From: David Fuller [REDACTED]
Sent: 17 June 2015 11:01
To: Ross Leal
Cc: Sophie Masson; AFA Fuller
Subject: Russet House - K/17/15/HH - Response to objections

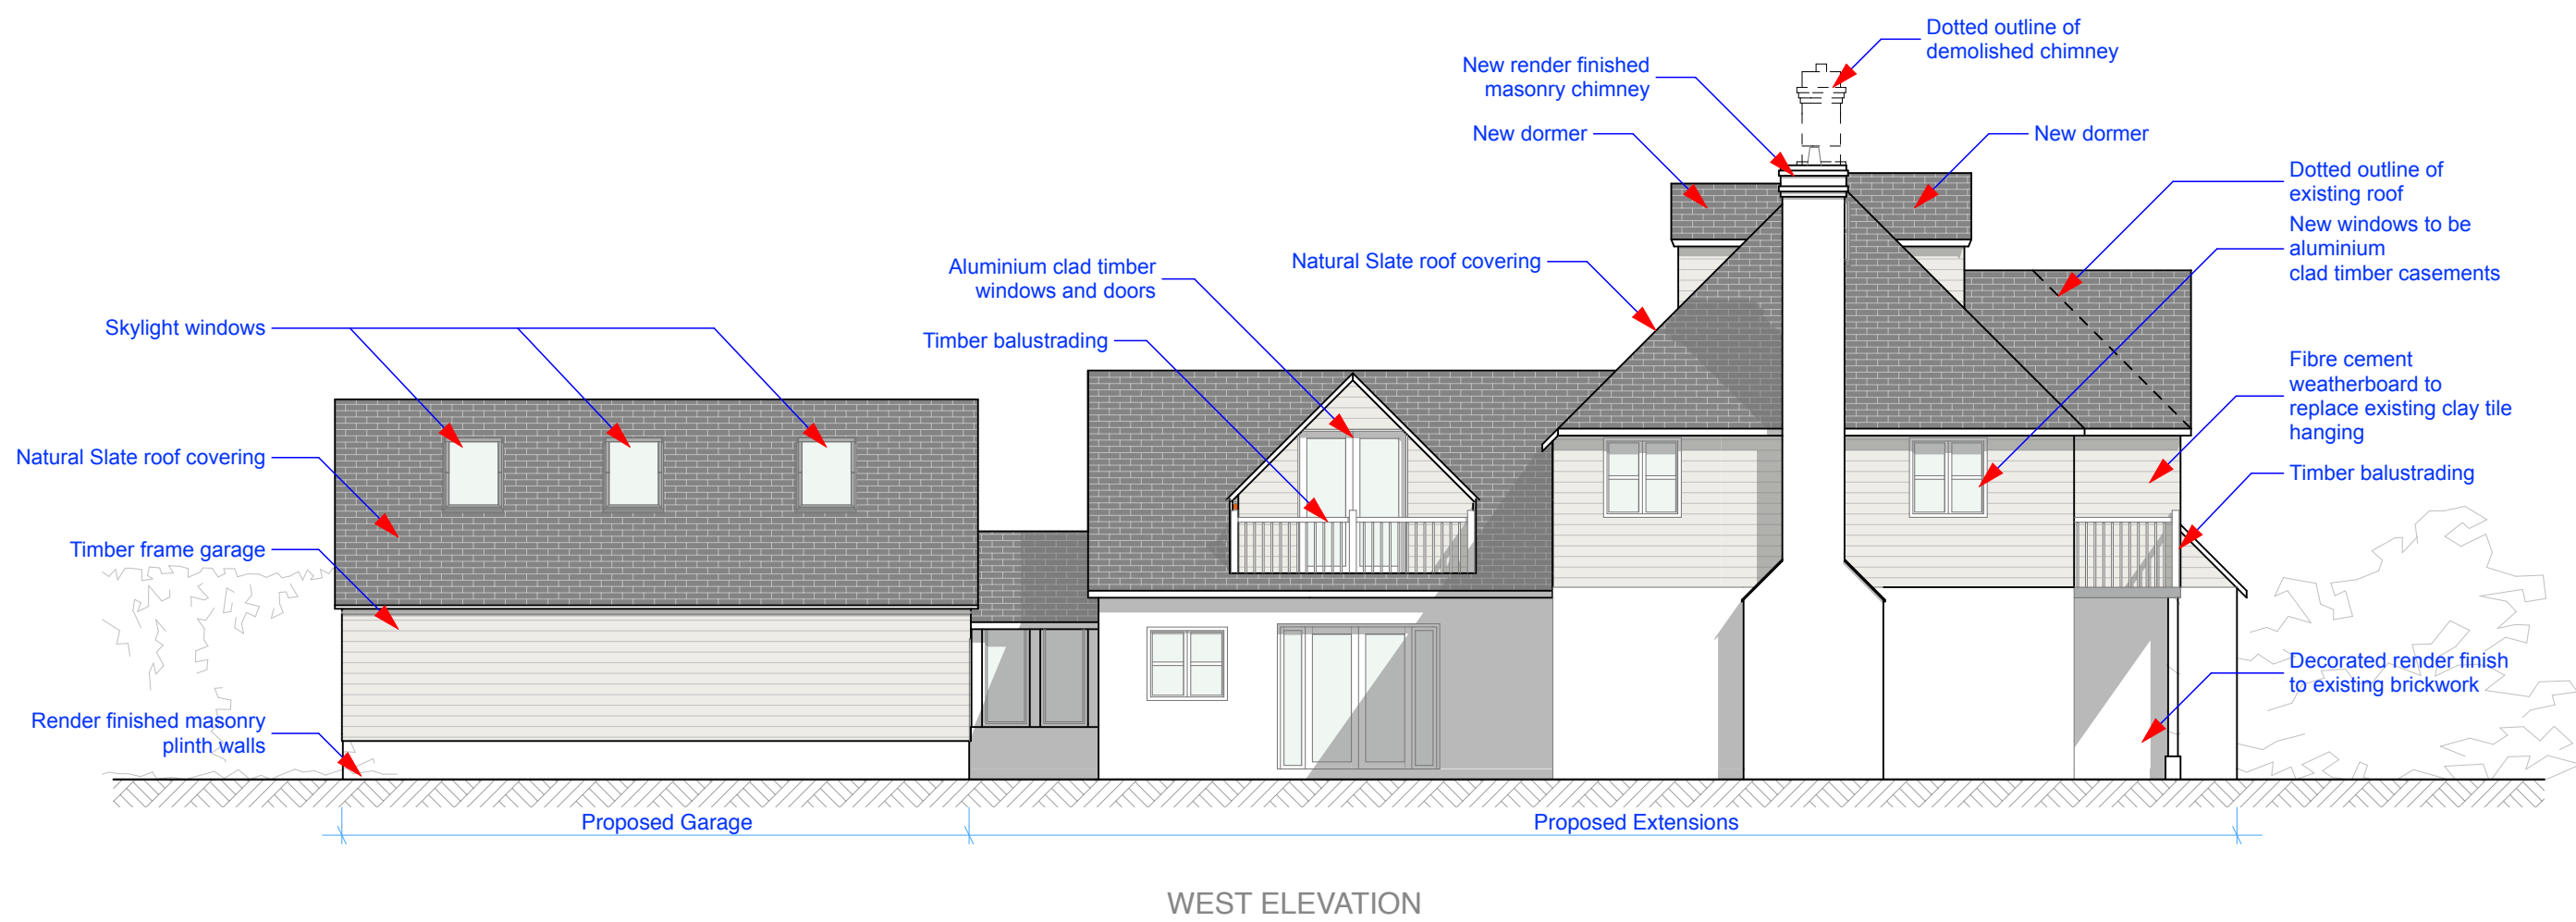
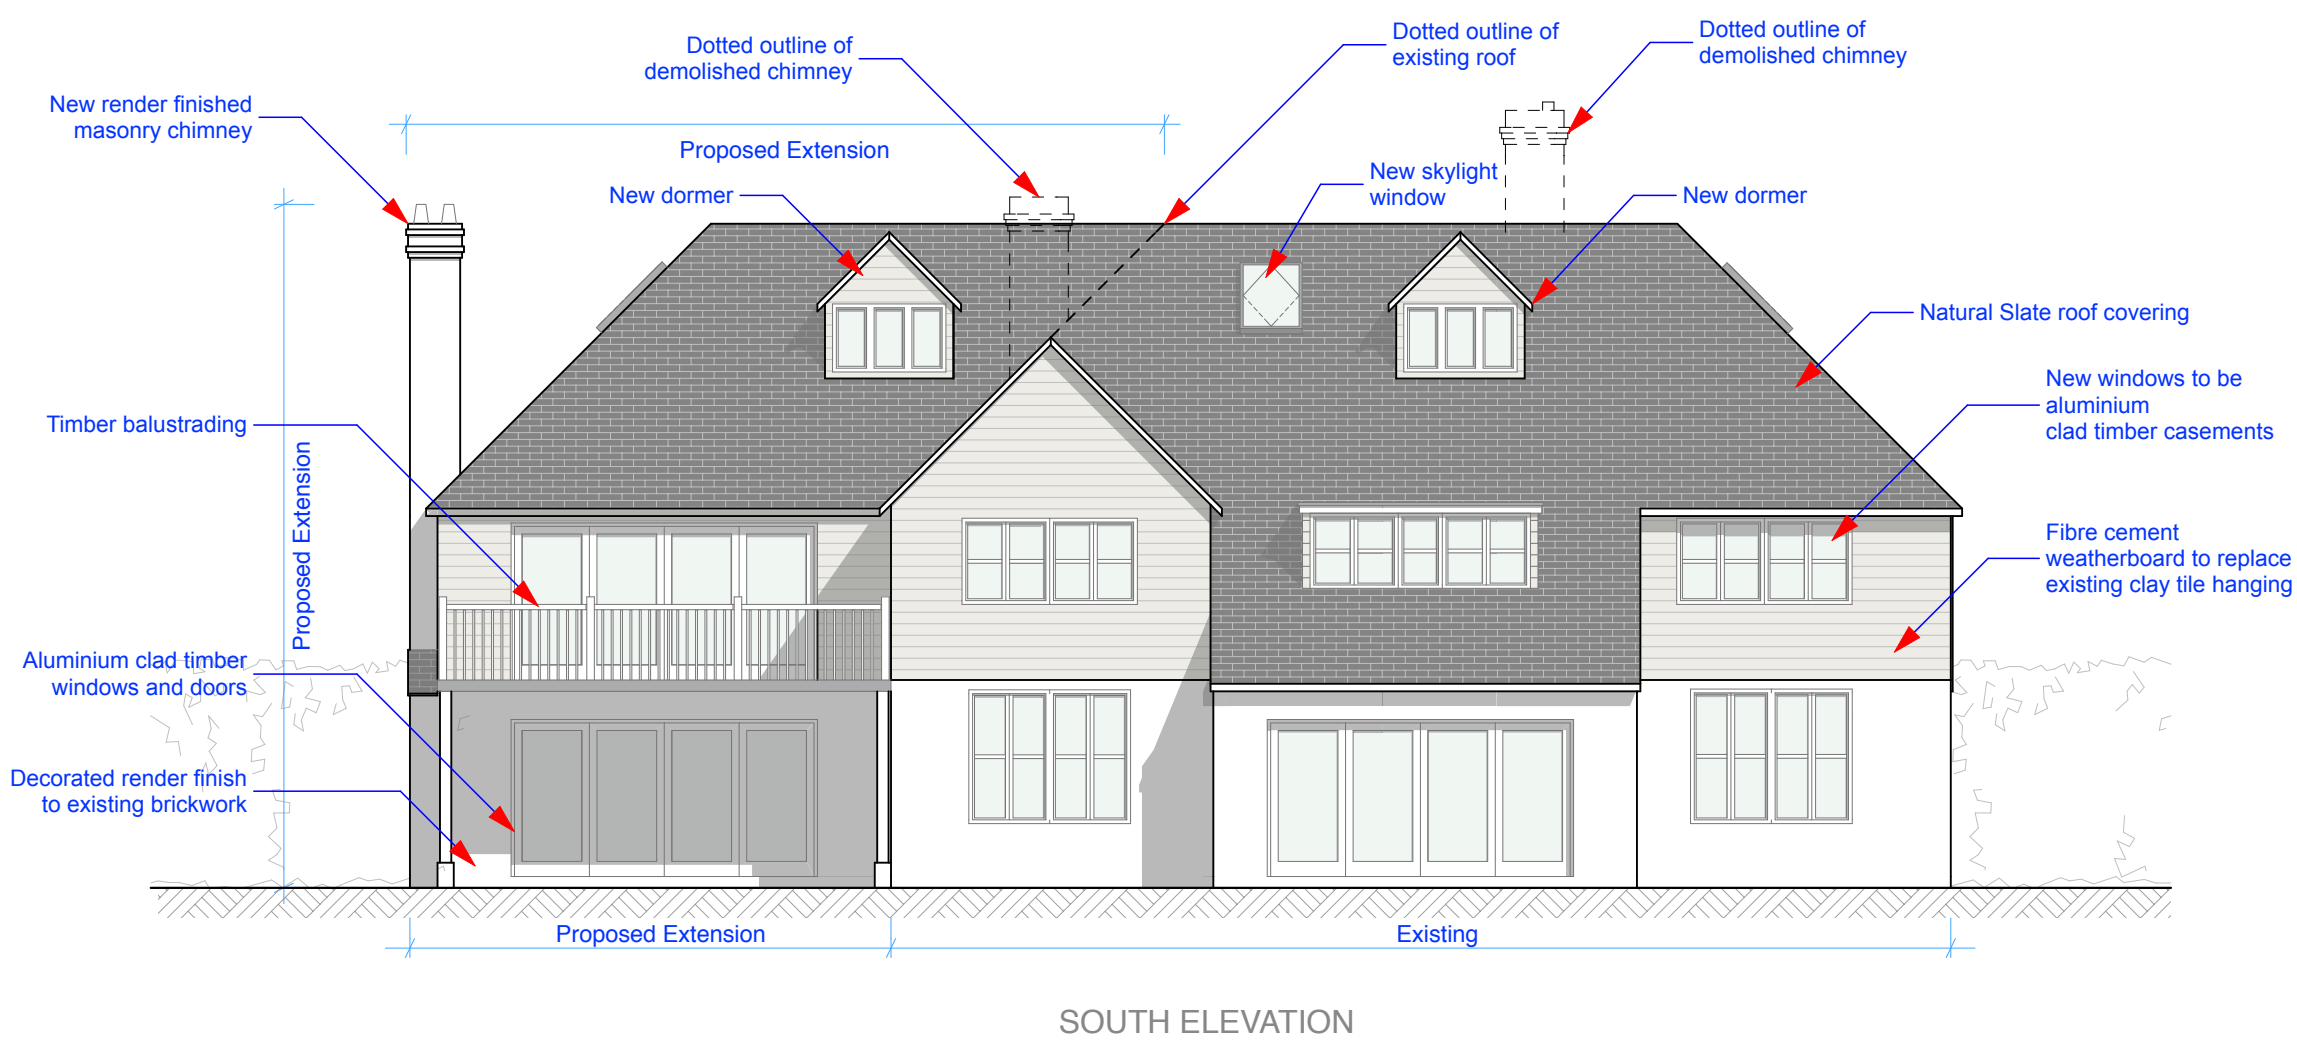
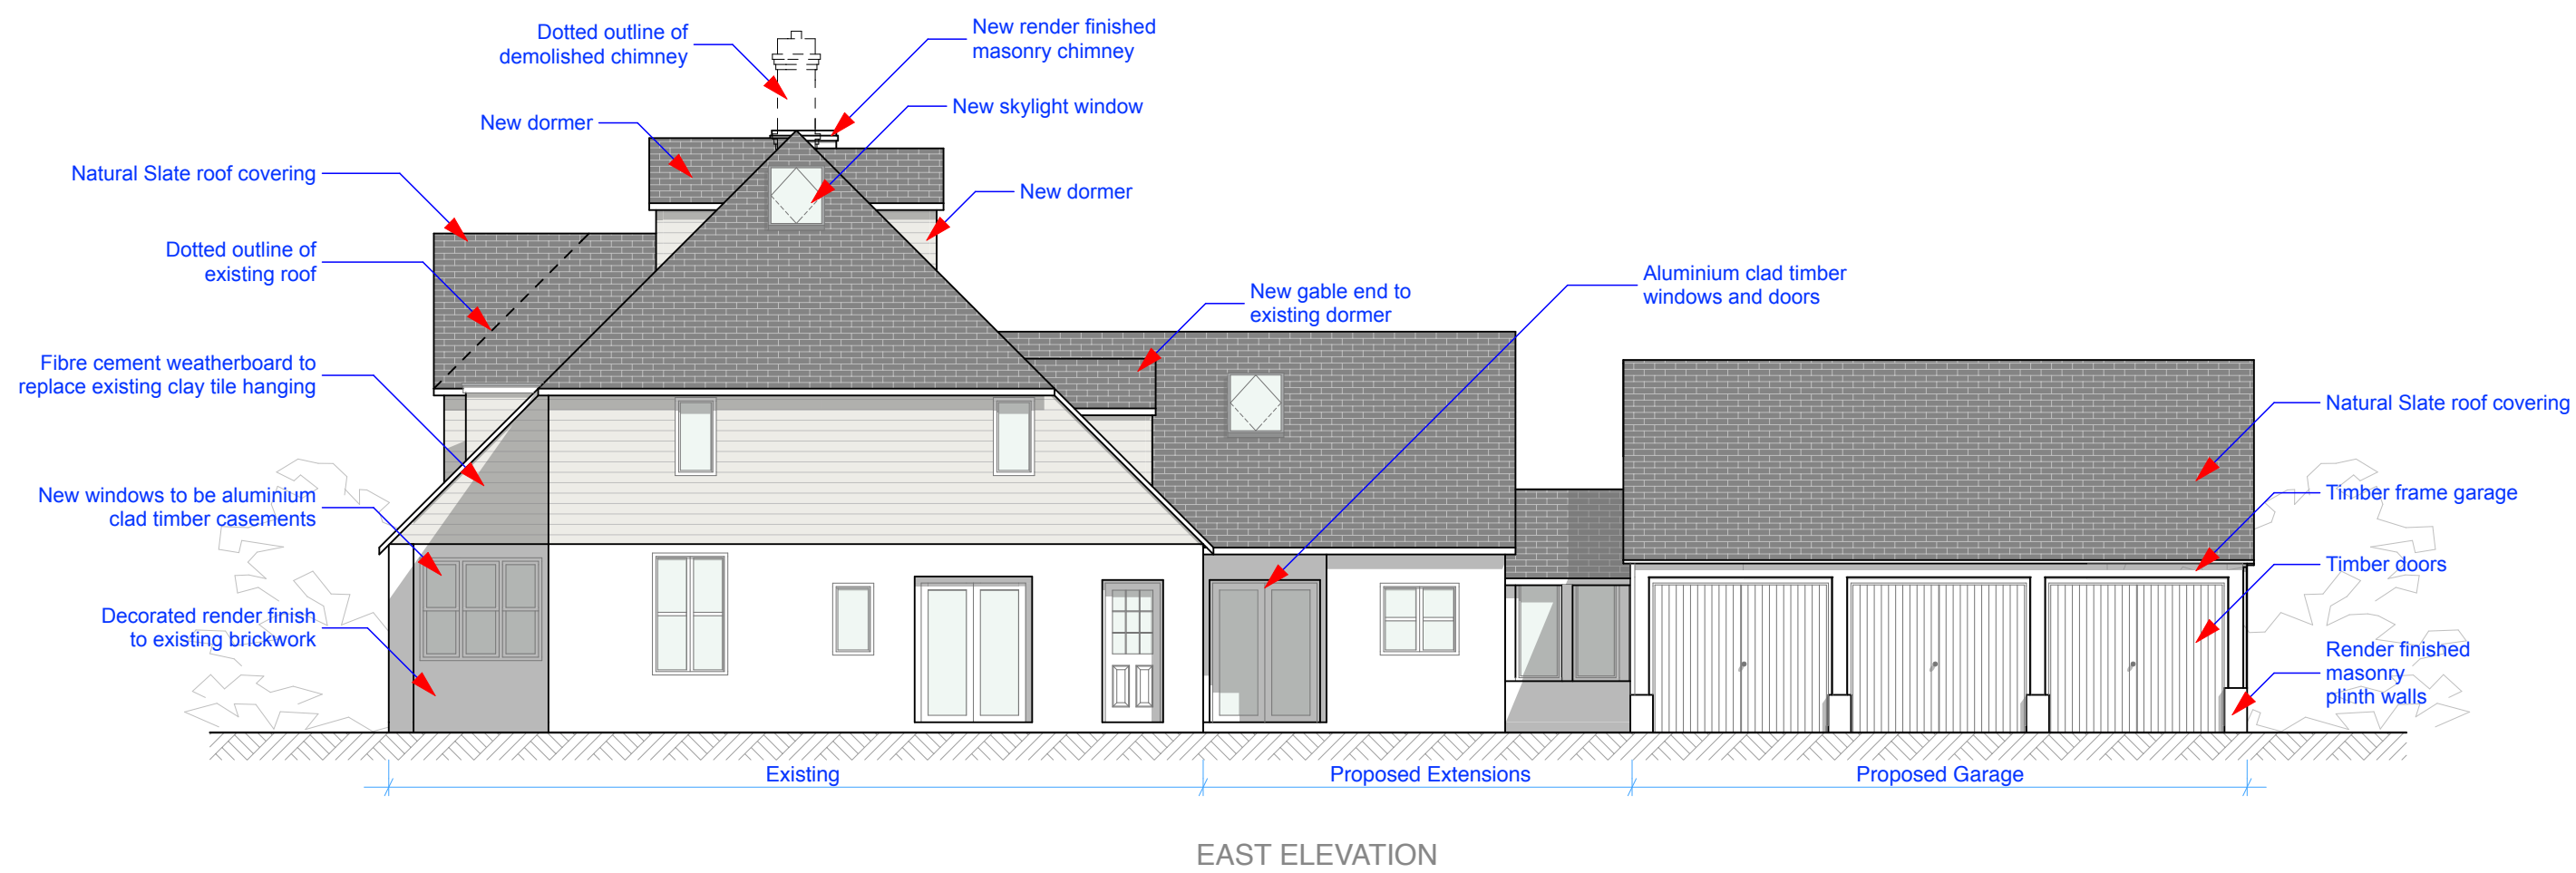
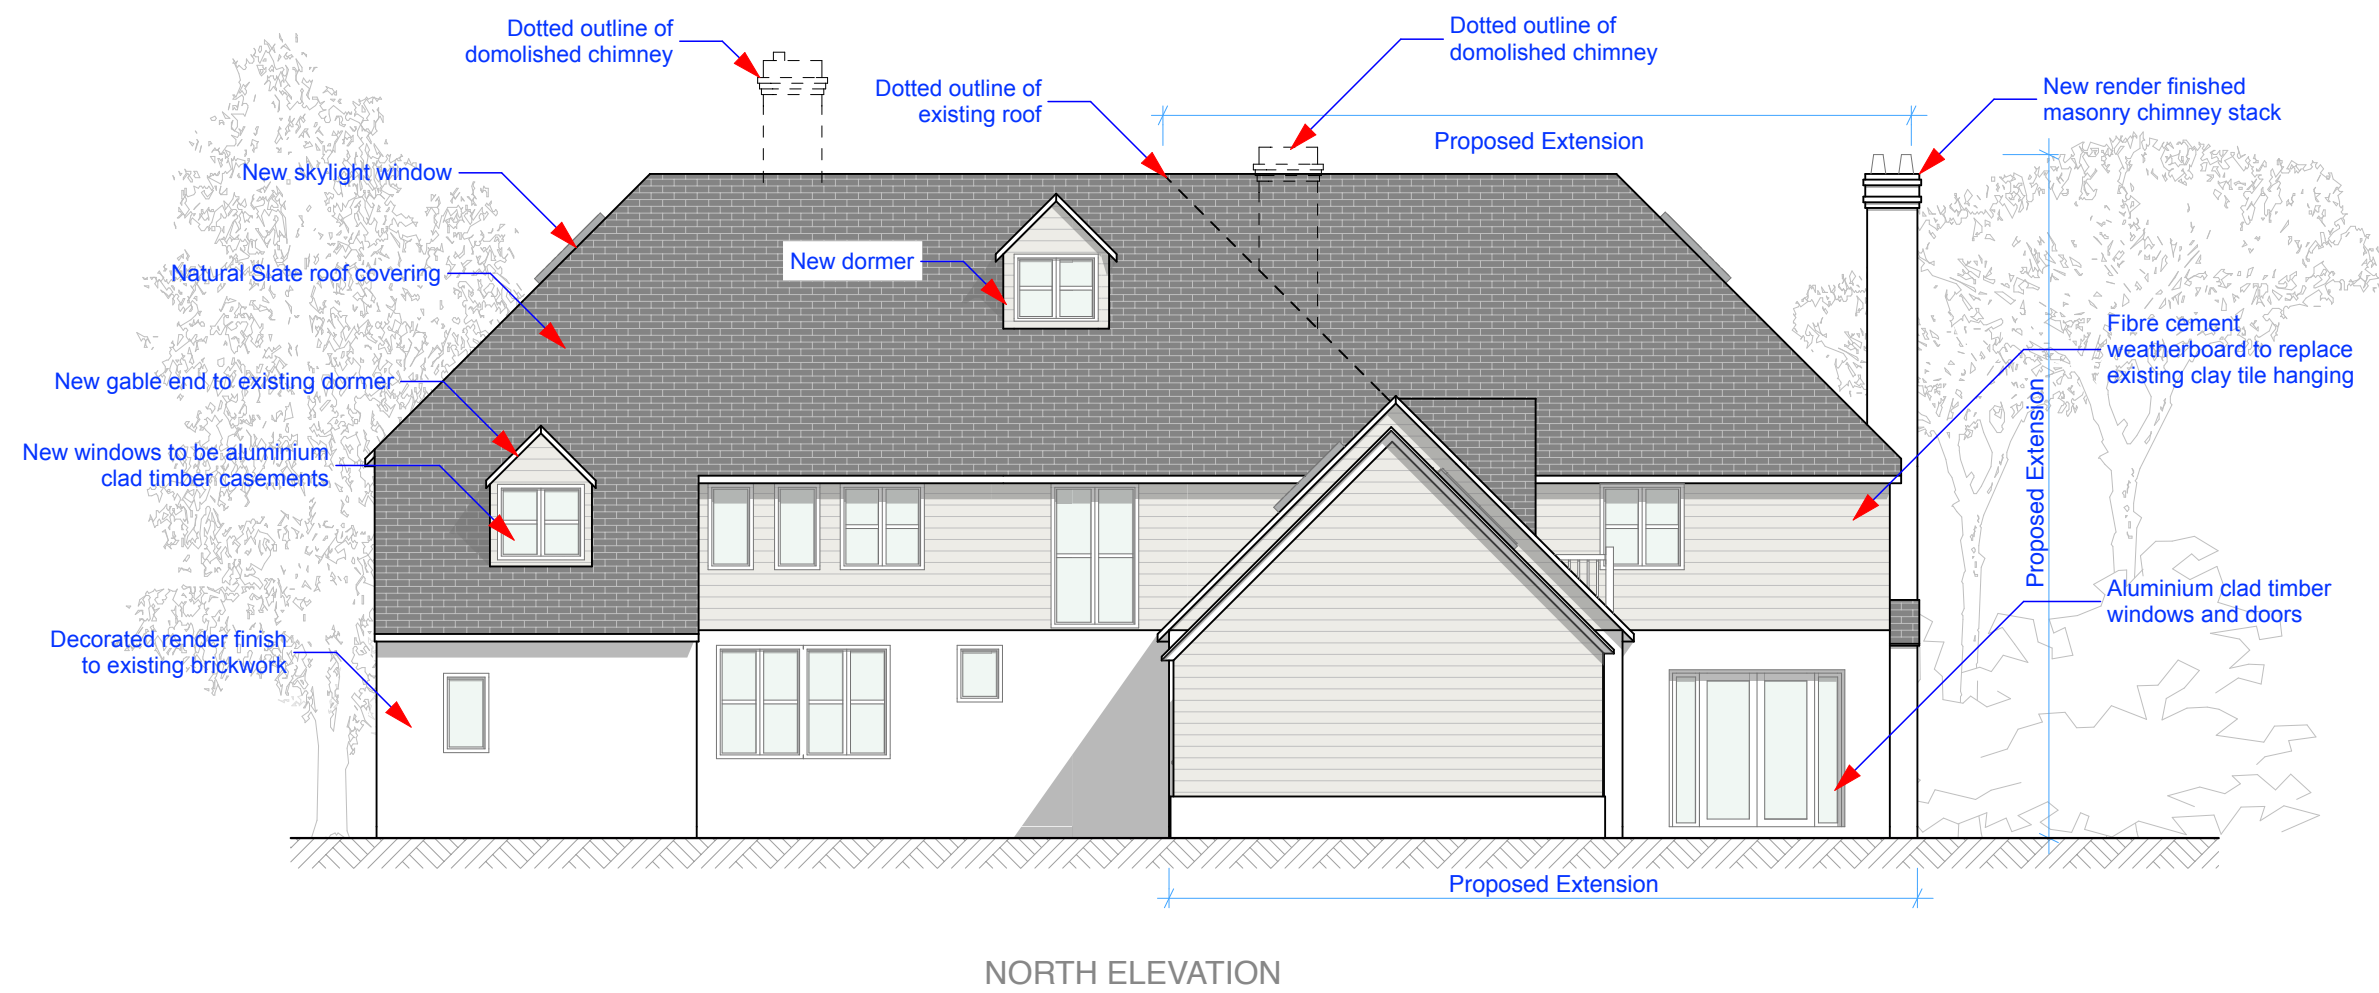
- 5) Mr Coope - Finale House - has objected to the second floor dormers, as he feels that they would overlook the North Elevation of this substantial property. In reality, the Eastern half of the North Elevation to Finale House is shielded from view by 3 mature trees to the Southern boundary of Russet House. Furthermore, the

Northern Elevation of Finale House is some 40 meters away from the South Elevation of Russet House, and we feel that there will be no overlooking potential from the new top floor bedroom windows as a result of the distance.
